PROJECT NO. PR-2021-005717

DESCRIPTION: Submittal to address Sketch Plat comments to supplement the preliminary plat application.

RE: Volcano Mesa at The Trails / Tract 2, Unit 2, The Trails
Sketch Plat Comments / Responses – DFT Hearing 08/02/2023
PR-2021-005717
PS-2023-00132 – Sketch Plat
Agenda Item No.: 6

TRACT 2 TRAILS
 DEFERRED SIDEWALK EXHIBIT
 July 11, 2023

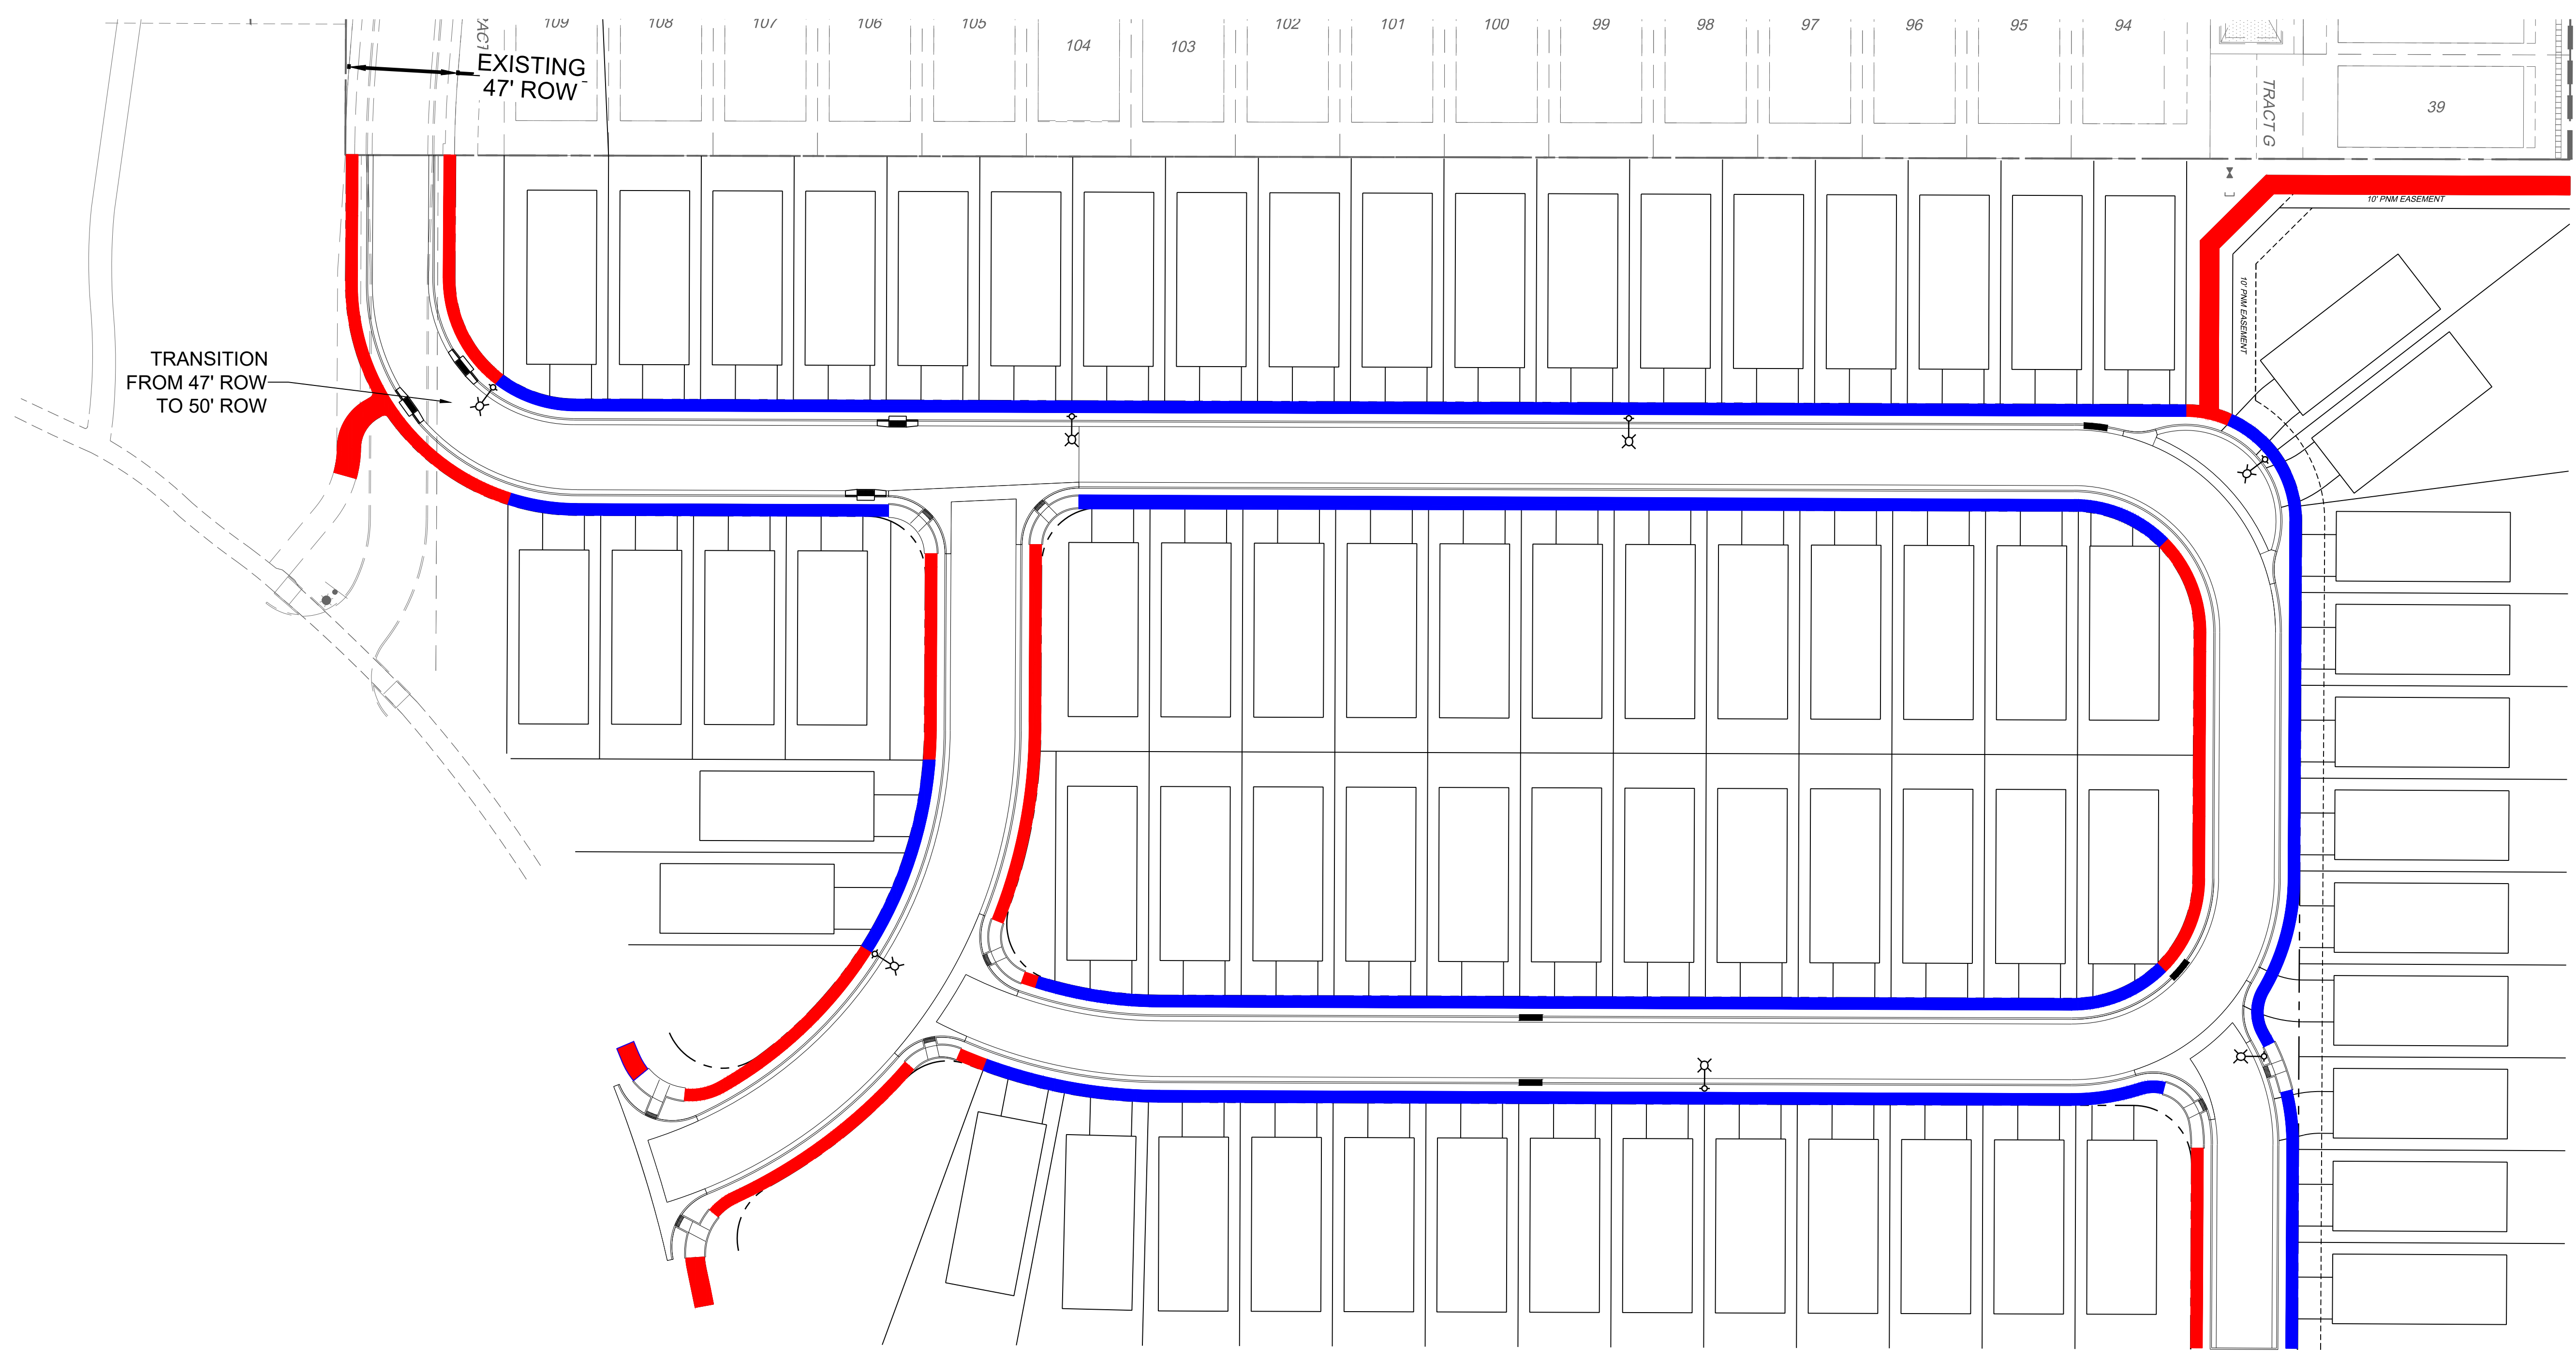
- The construction of some of the sidewalks is depicted as being deferred per the Deferred Sidewalk Exhibit included in the application. A Deferral of Sidewalk Construction application must be

submitted and approved administratively separately from the Preliminary Plat, Waiver, and Vacation applications.

RESPEC Response: Acknowledged. The Deferral of Sidewalk Construction application will be submitted by Tuesday, August 15, 2023.

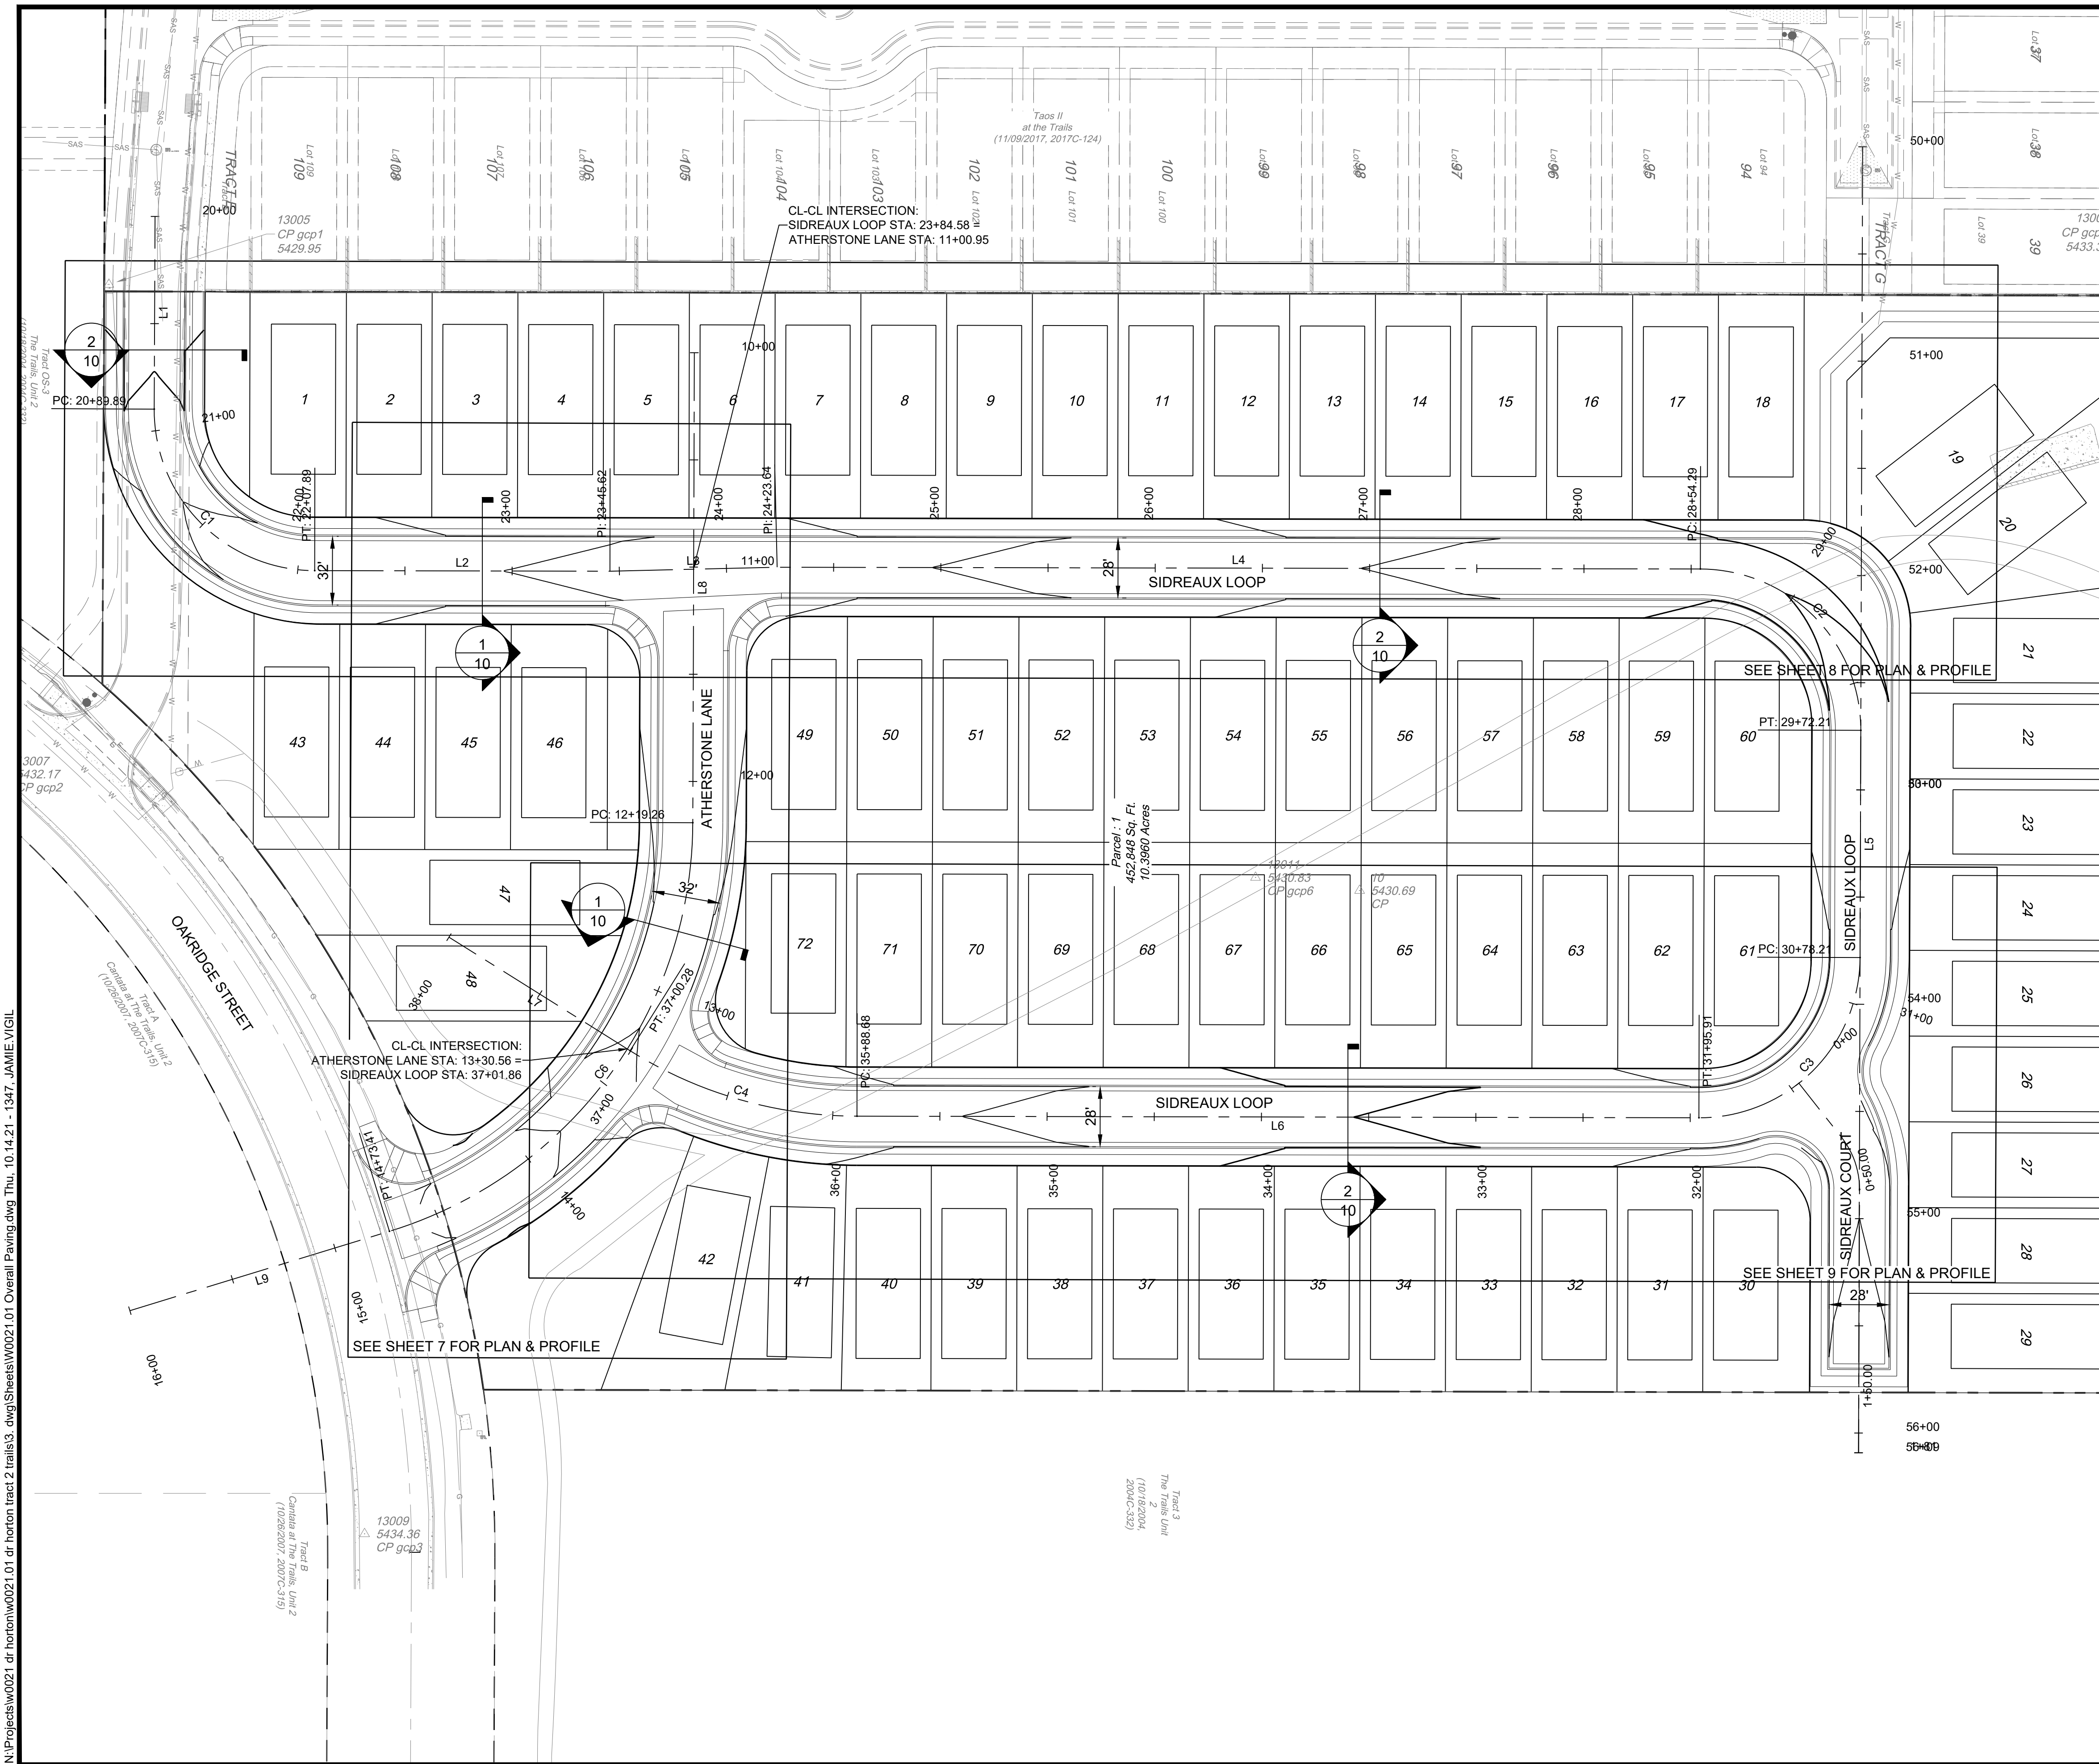
1. A minimum 75-foot radius is required at roadway curves. Label all centerline radii.

RESPEC Response: All roadway curve radii meet the 75-foot radius requirement. We have labeled all centerline radii.

1  
10 TYPICAL 32' STREET SECTION  
NOT TO SCALE

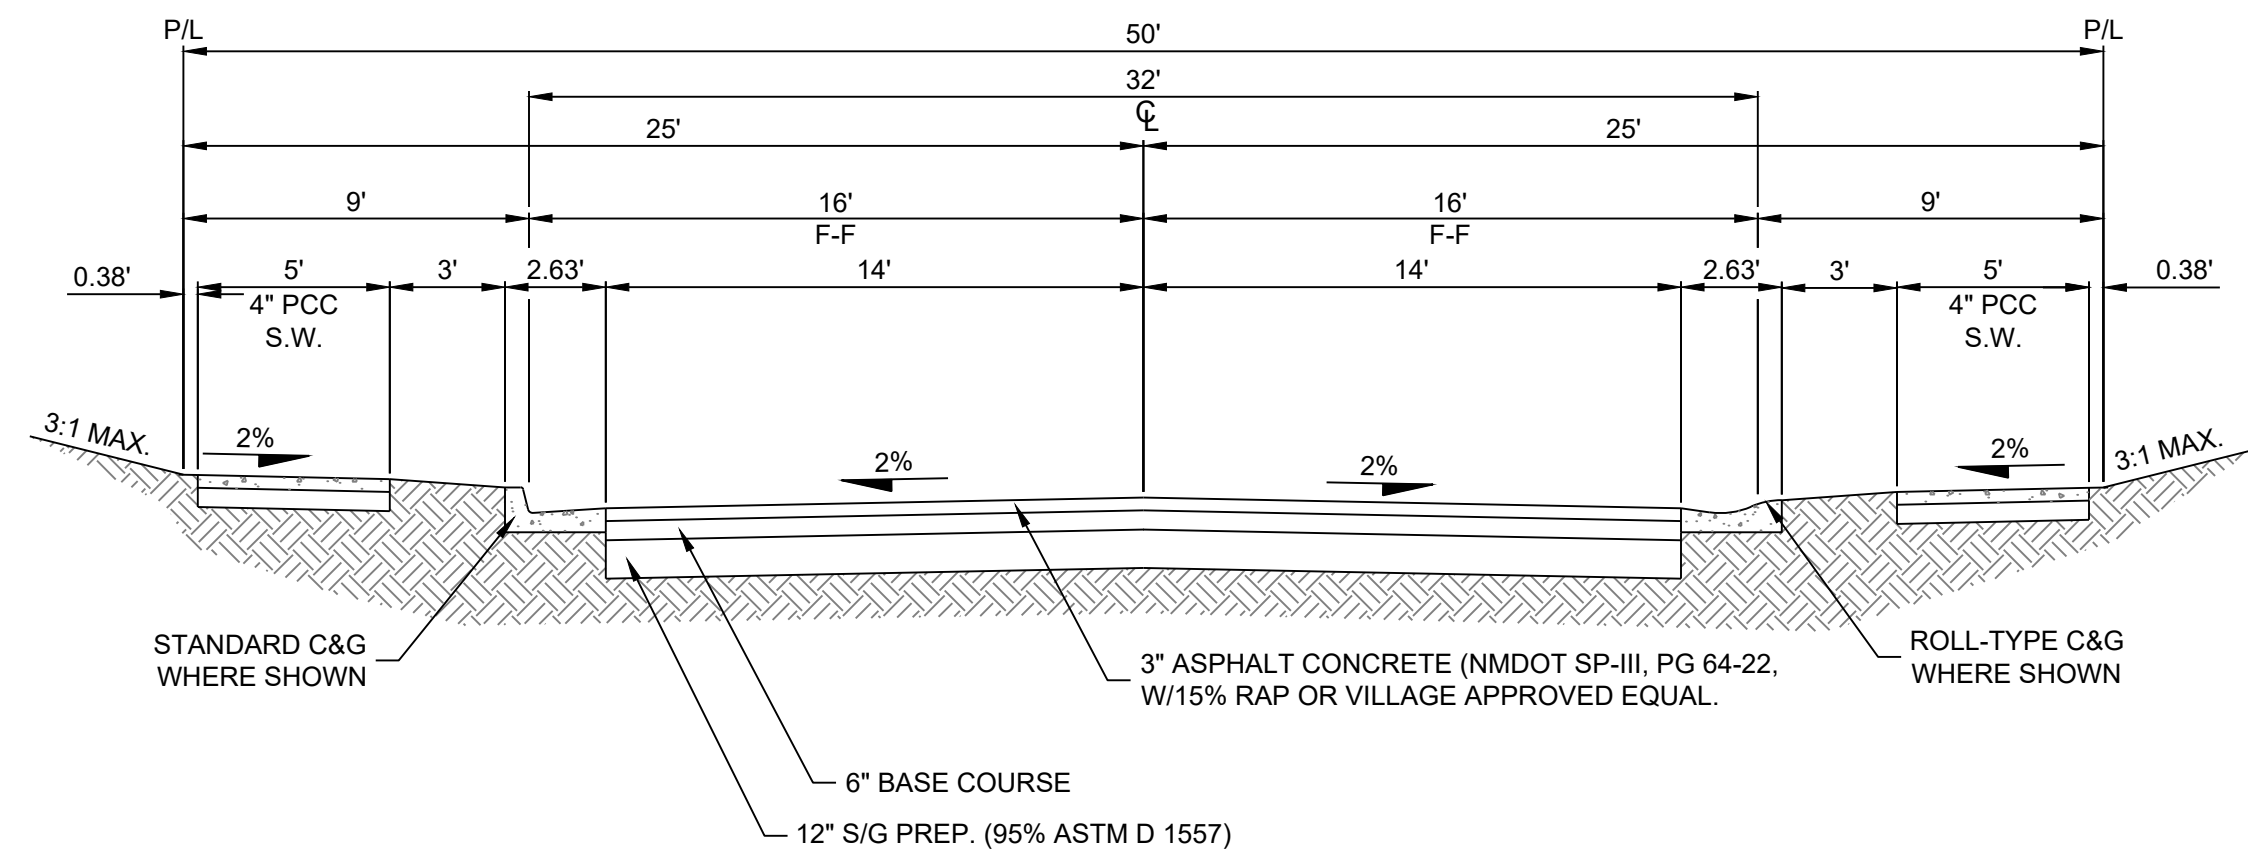
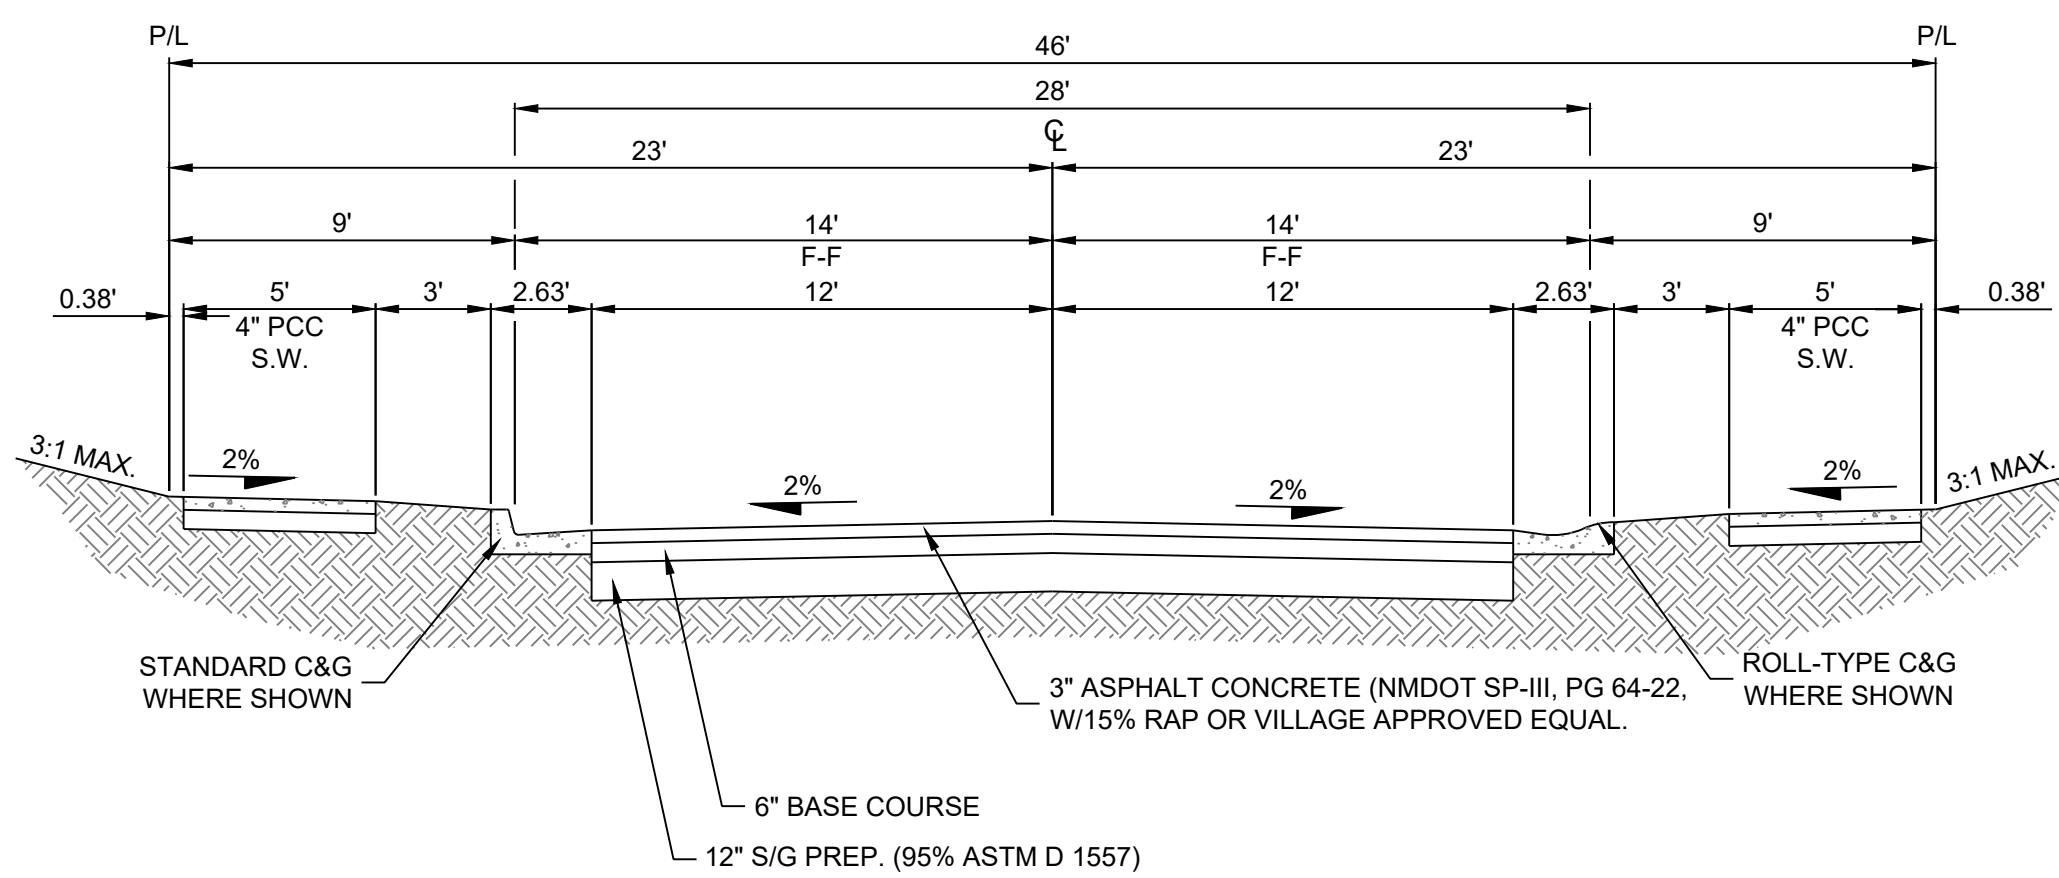
2. Please provide road cross-section for all interior roads. A 5' sidewalk with a 4-6' landscape buffer is required as these are local roads.

RESPEC Response: We provided roadway cross-sections, including landscape buffers, to DRC and which had been approved on April 6, 2023. These streets have been built per these construction plans.
